DEVELOPMENT REVIEW BOARD  
TRANSPORTATION DEVELOPMENT

DRB Project Number: 1011569  
**Parkland Hills**

SUBJECT: Sketch Plat

PLAT OF LOTS 1-A & 1-B, BLOCK 25 PARKLAND HILLS

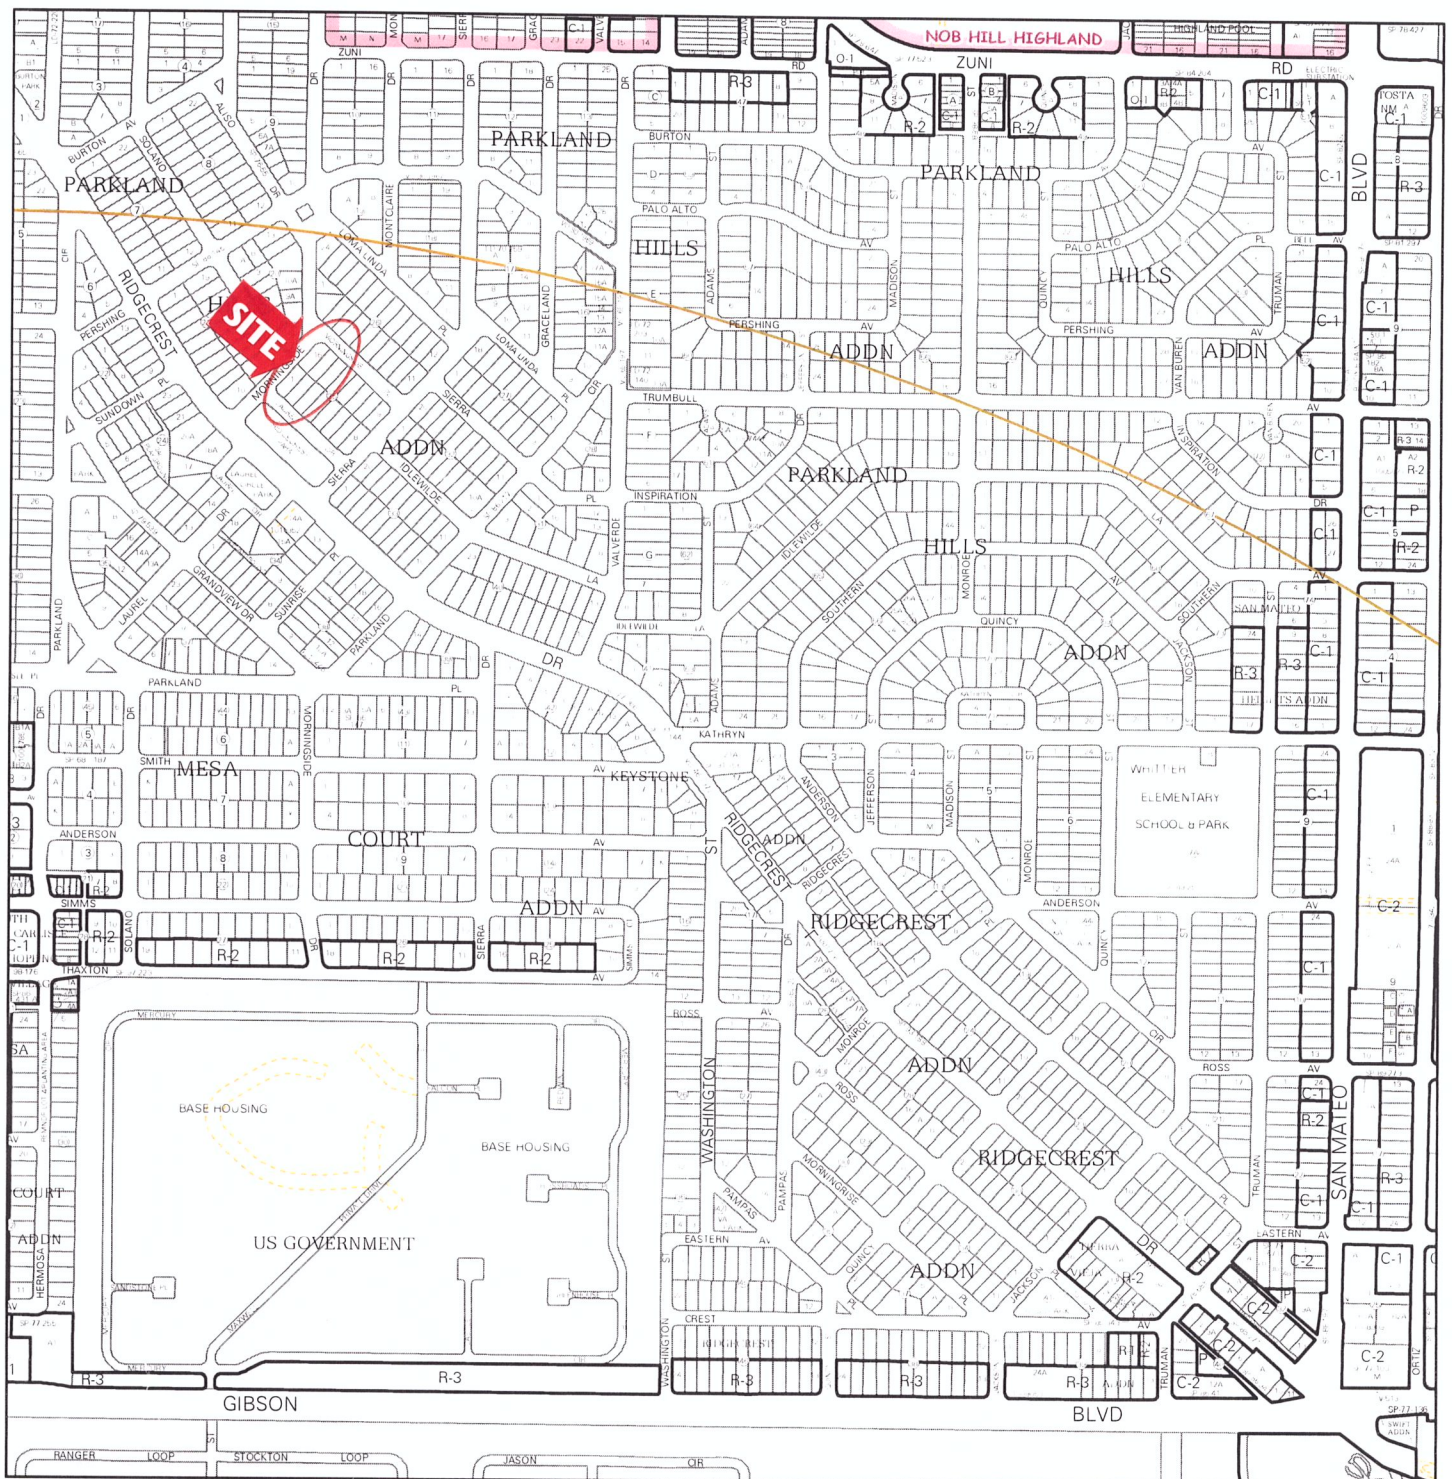
1. Provide a sidewalk exhibit showing the location, width, and defining the distance from back of curb to the property line. Right of way dedication may be required.
